From: Sue Howell
Sent: 20 February 2025 12:45
To: Planning.Responses
Cc: Jessica Riches
Subject: Planning Consultation on: F/14/24/RES, F/15/24/RES, F/16/24/RES

Response to Planning Application

From: Arun District Council Leisure & Greenspace

Location: Land at Ford Airfield Ford

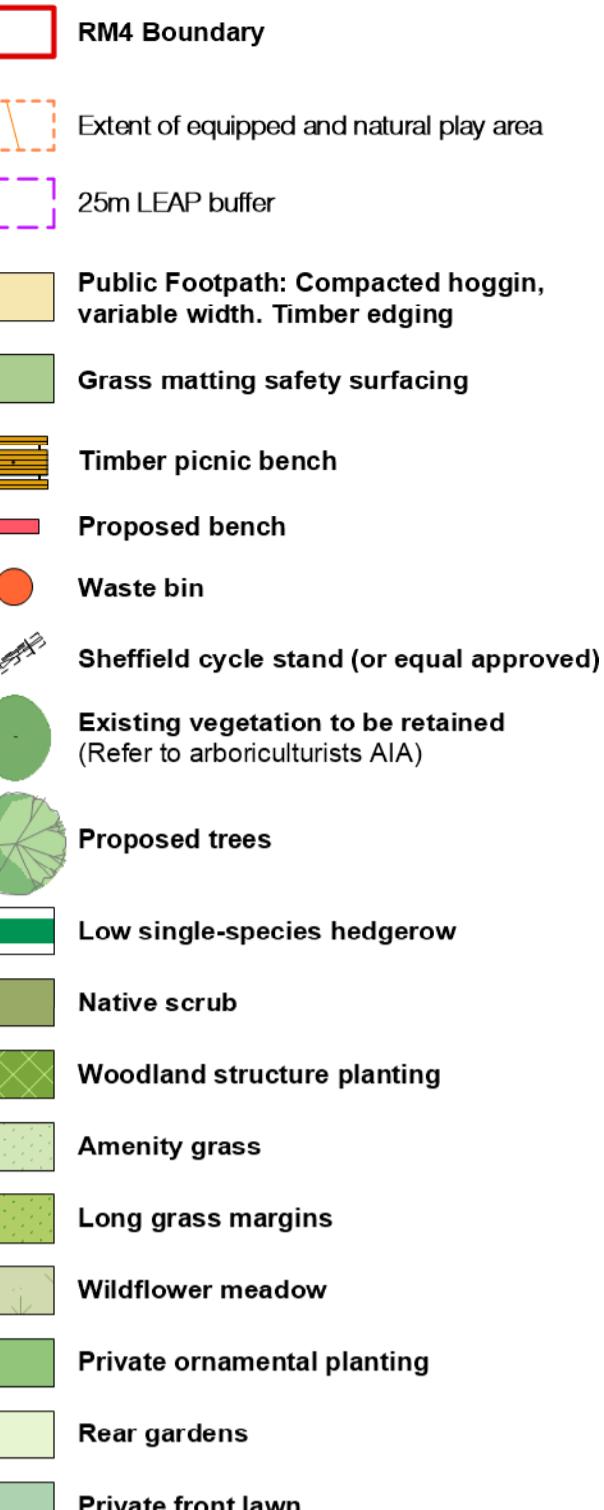
Play Areas were previously advised required amendments to maximise play space and reduce duplication of play items - Note on drawings RM4-XX-DR-L-P-031 and RM4-XX-DR-L-P-032 explains the play spaces are shown indicatively, to be agreed in consultation with ADC and secured by condition. **Request** condition for play
